## **NEWRIVER, FOUR ASHES PUBLIC HOUSE, FOUR ASHES**

### **APPLICATION BY FOUR ASHES LIMITED FOR AN ORDER GRANTING DEVELOPMENT CONSENT FOR THE WEST MIDLANDS INTERCHANGE**

### **CONNECT TECHNICAL NOTE 03 – OBJECTION ON BEHALF OF NEWRIVER TO PROPOSED RIGHT TURN BAN AT THE A449 STAFFORD ROAD / STATION ROAD JUNCTION**

**21<sup>ST</sup> AUGUST 2019**

Key
00 Total Vehicles
(0) HGVs
--- Site
--- New road

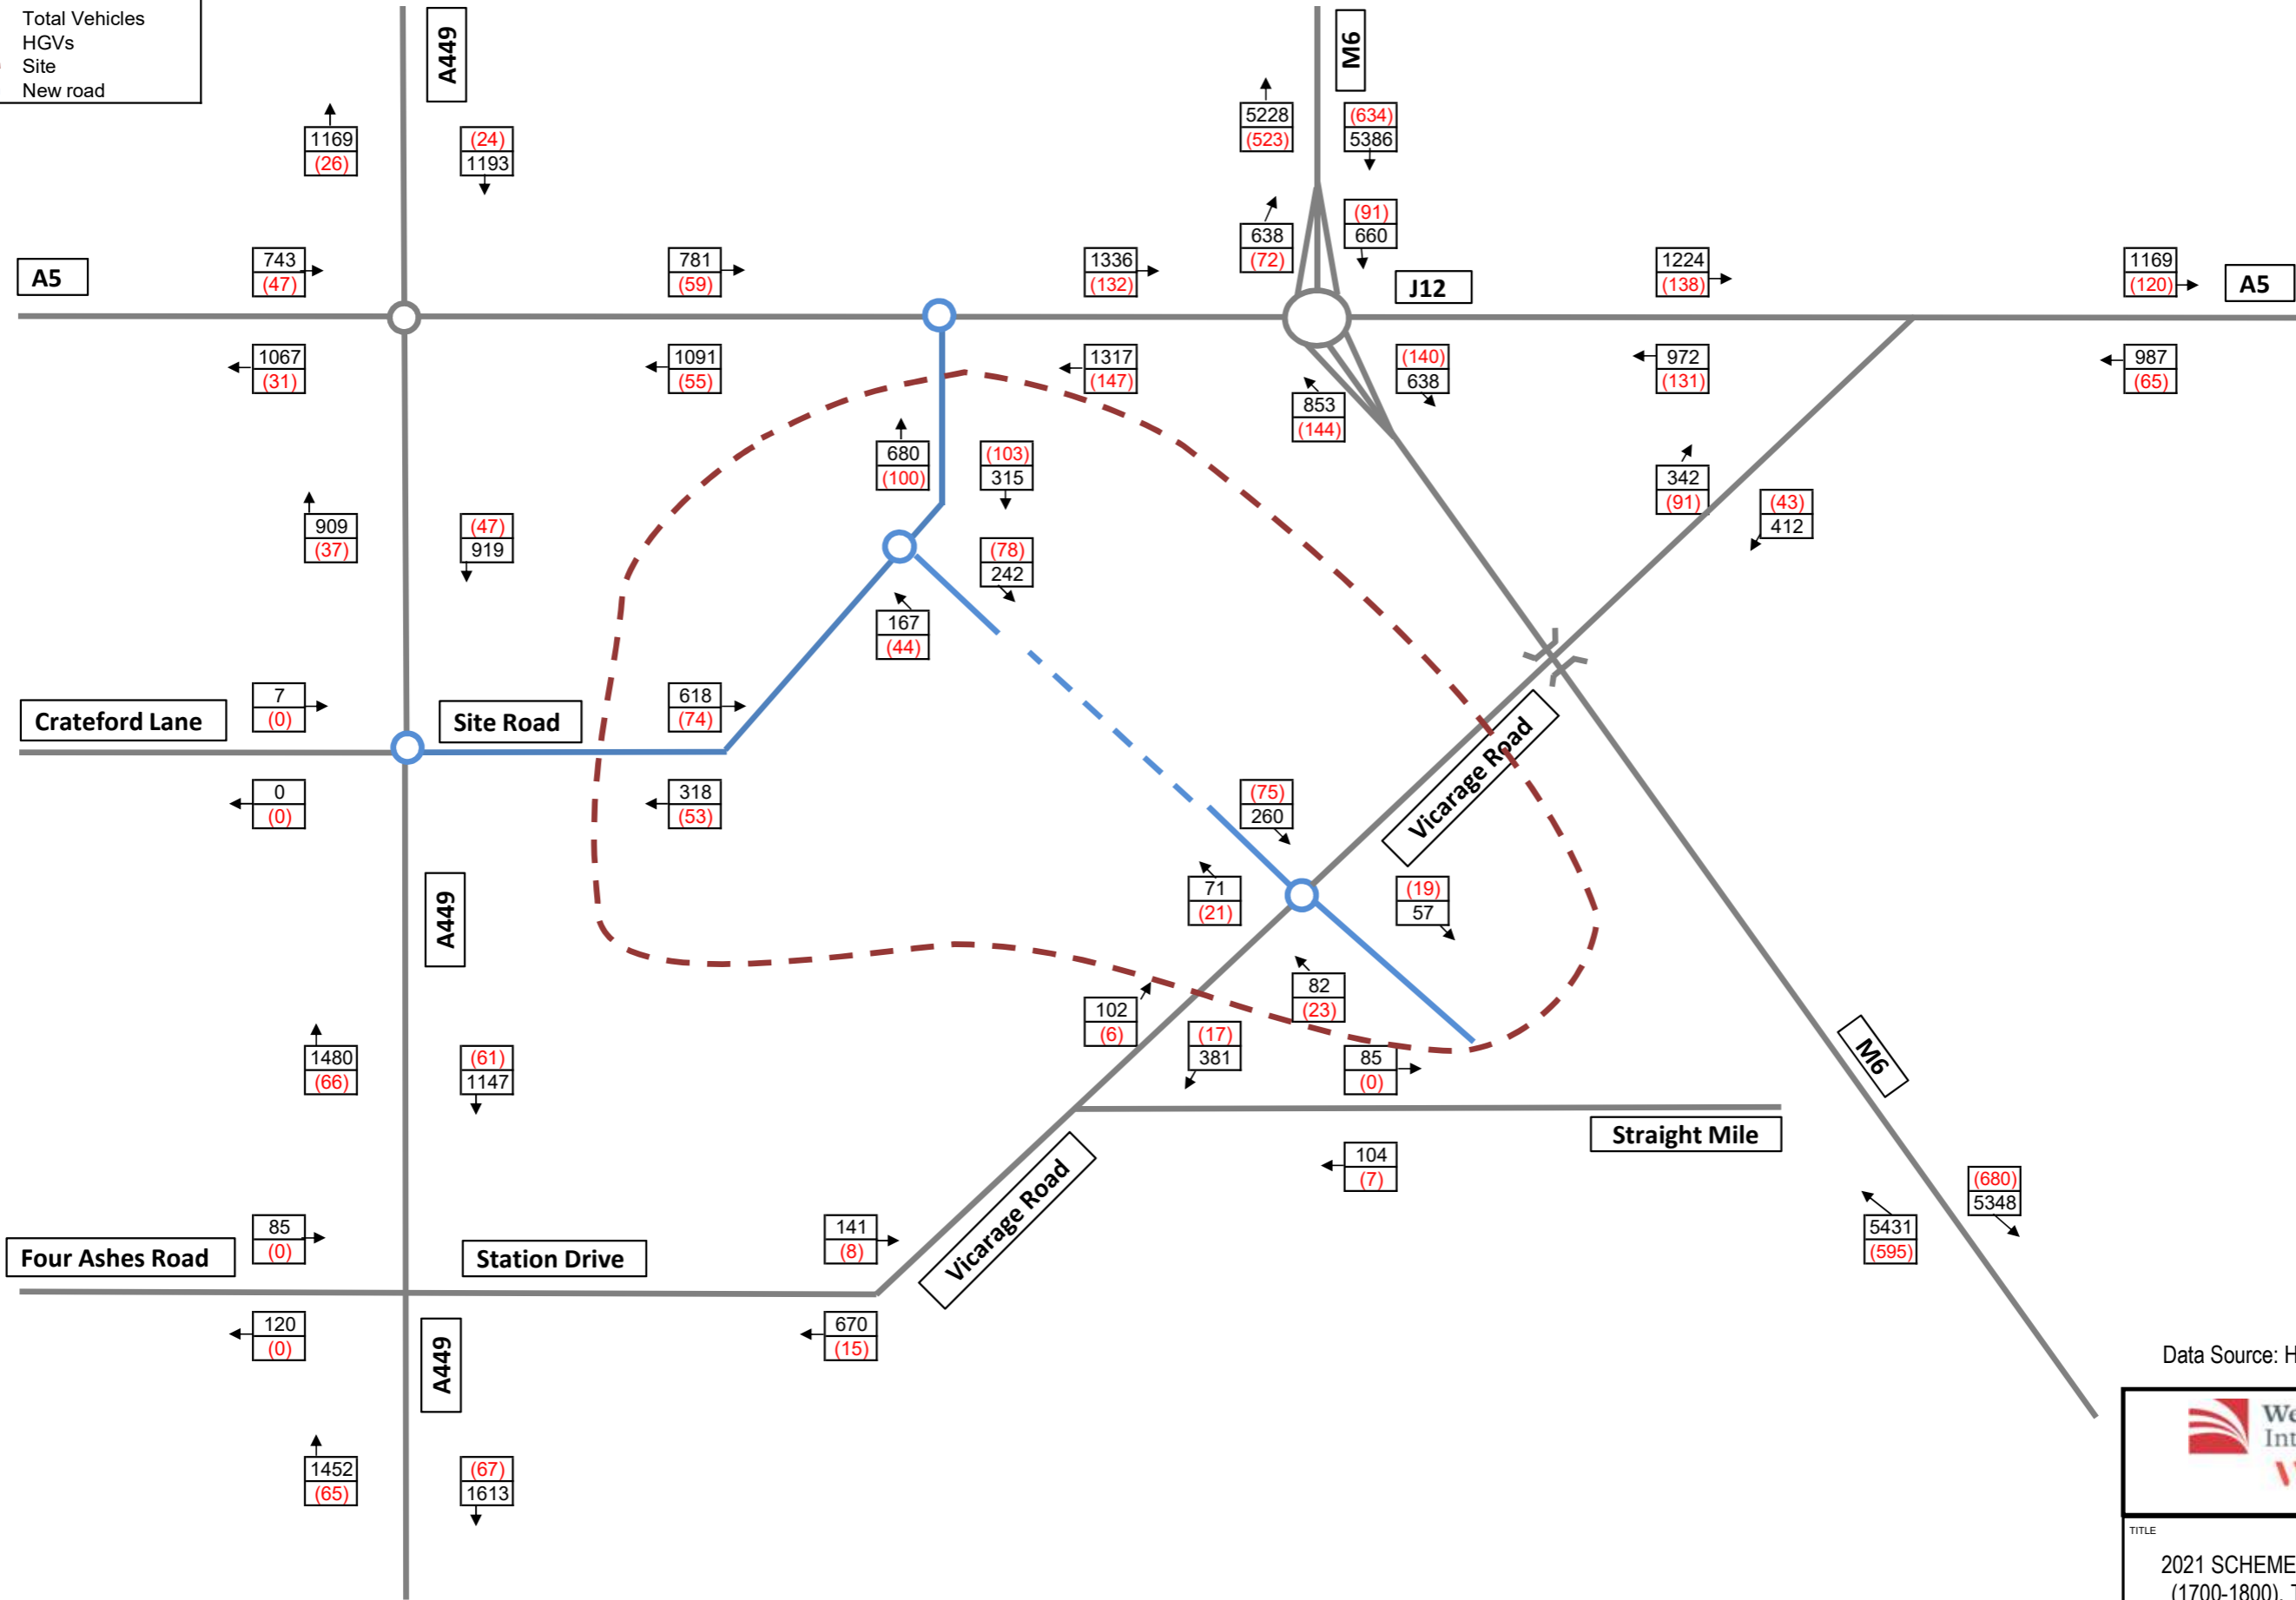
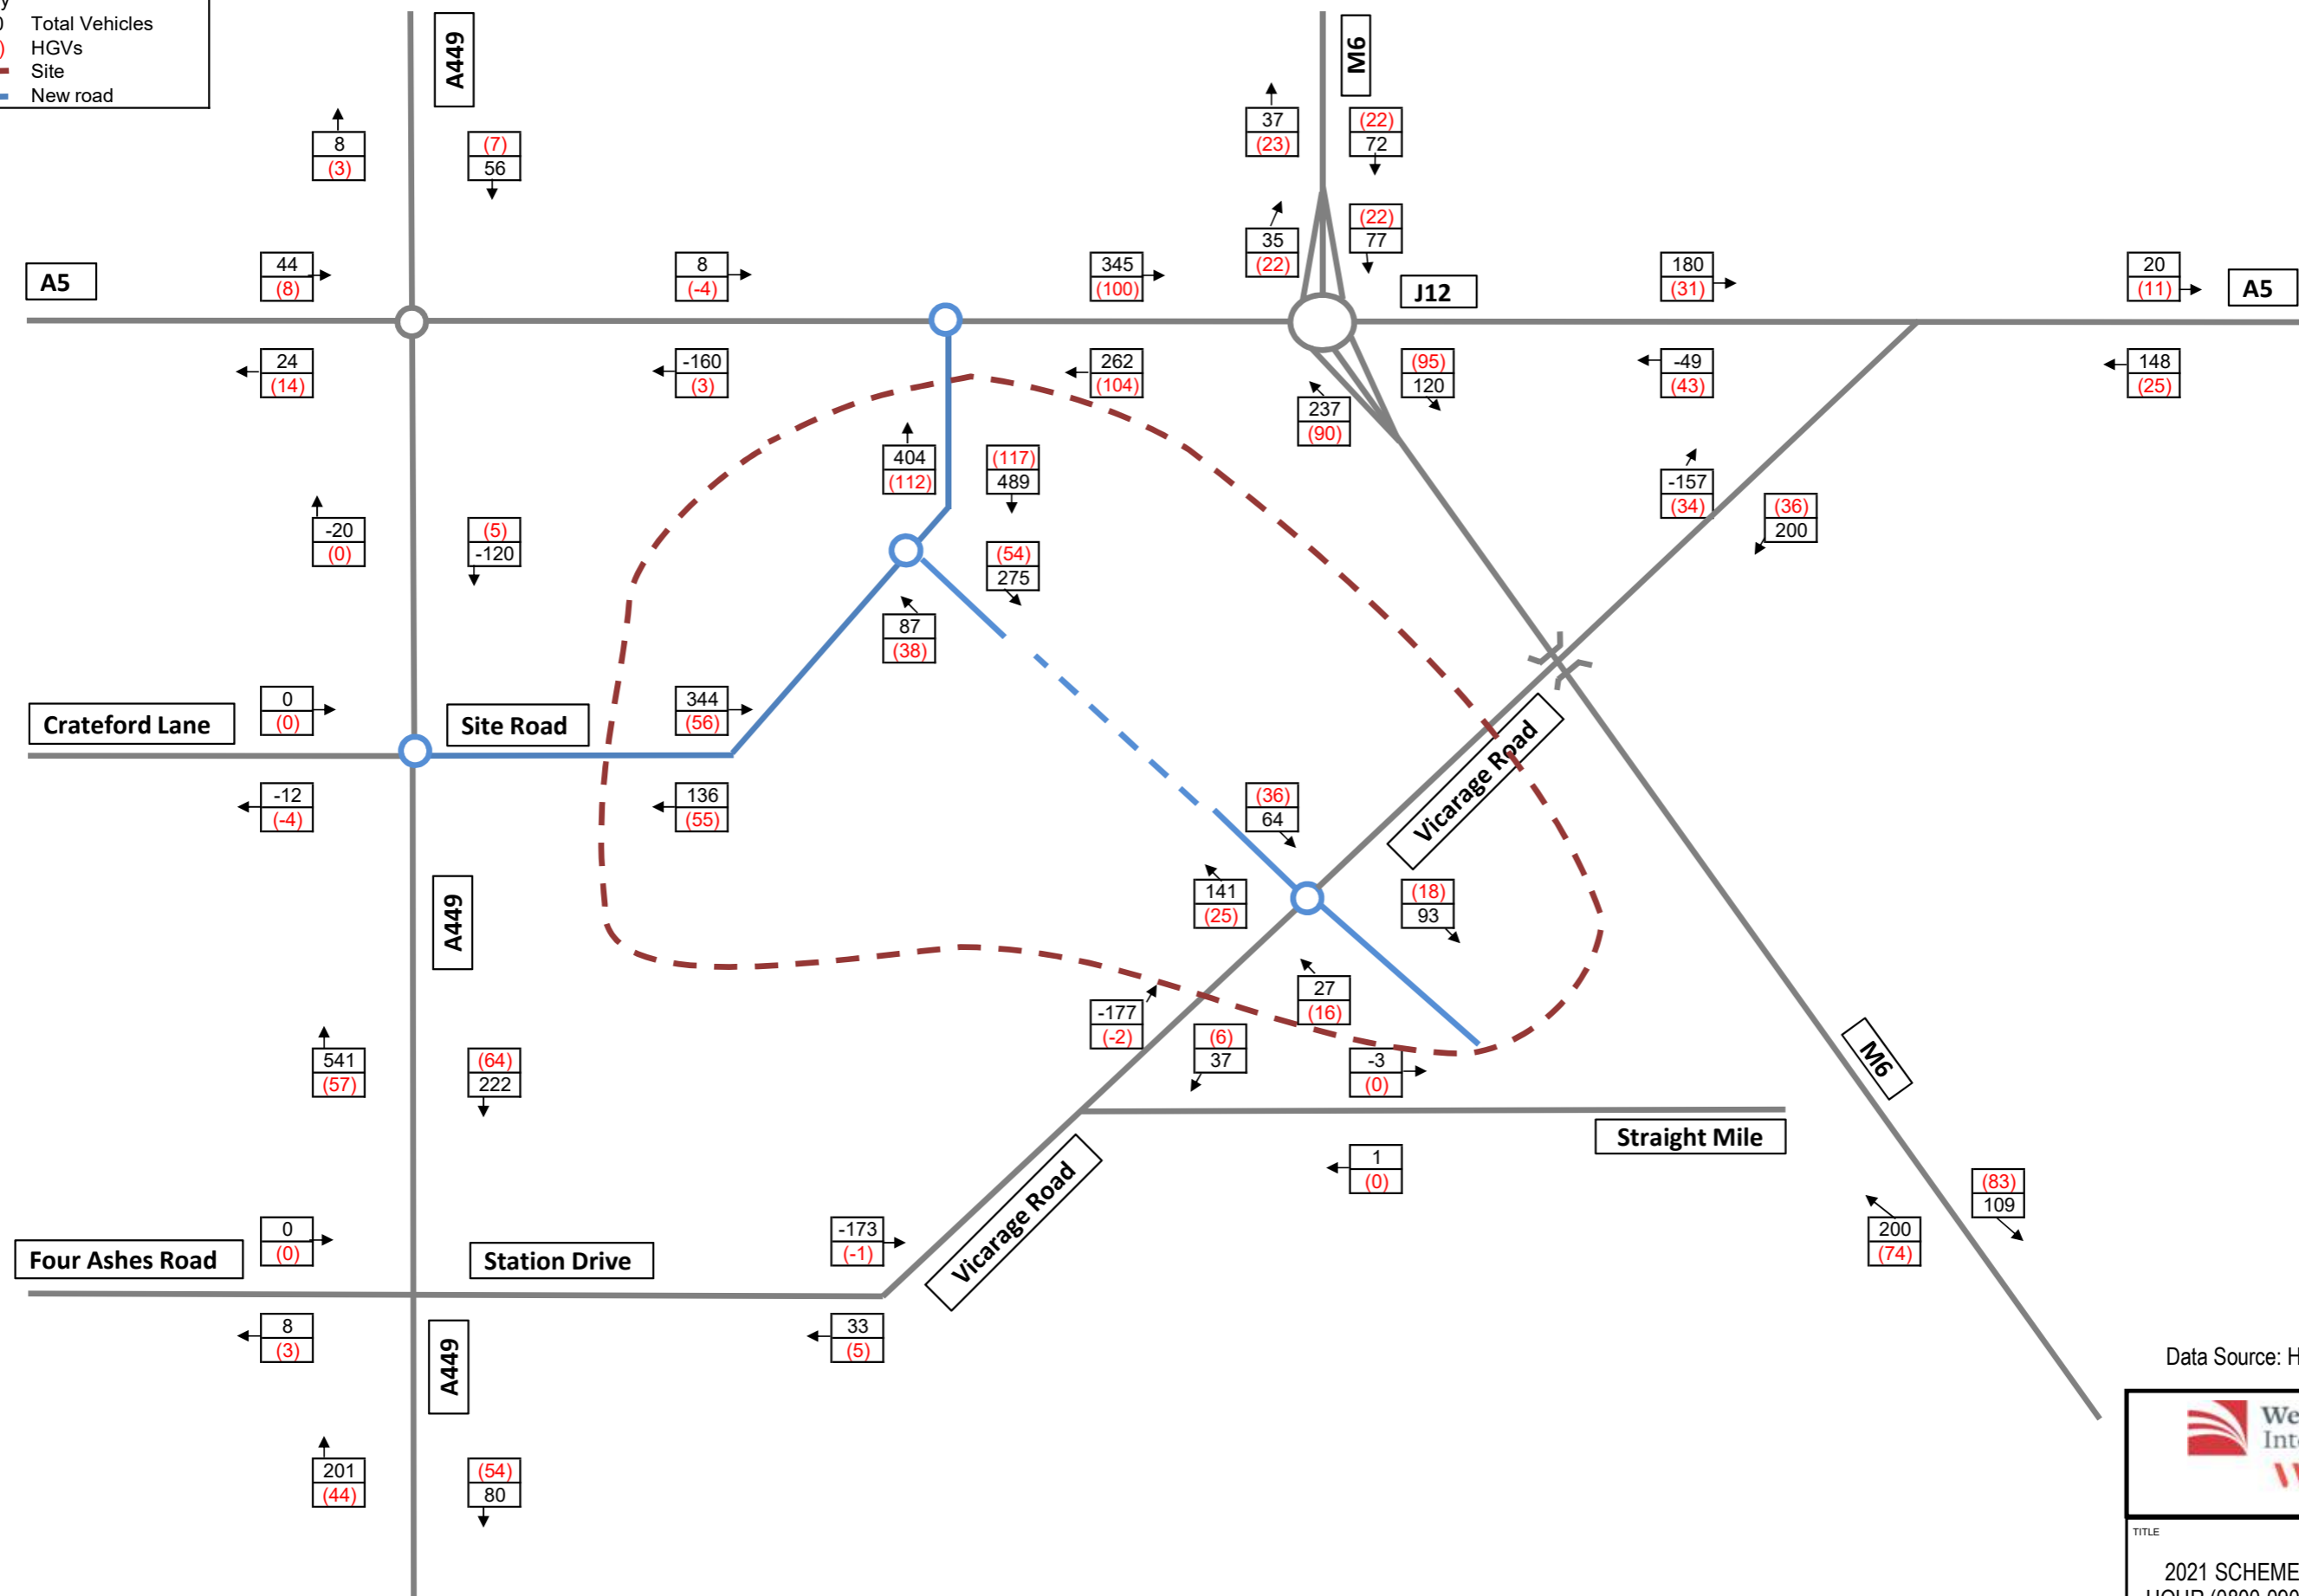
- WSP have still not presented accurate traffic flow diagrams (i.e. including U-turns at junctions) which raises questions regarding transparency.
  - Paragraph 2.5: WSP appears to be making a (diversionary) semantic argument relating to the meaning of "reduce", with the assertion that "remove" is not a subset of "reduce". This is equivalent to saying that any of the numbers one to nine are less than ten, but zero is not.
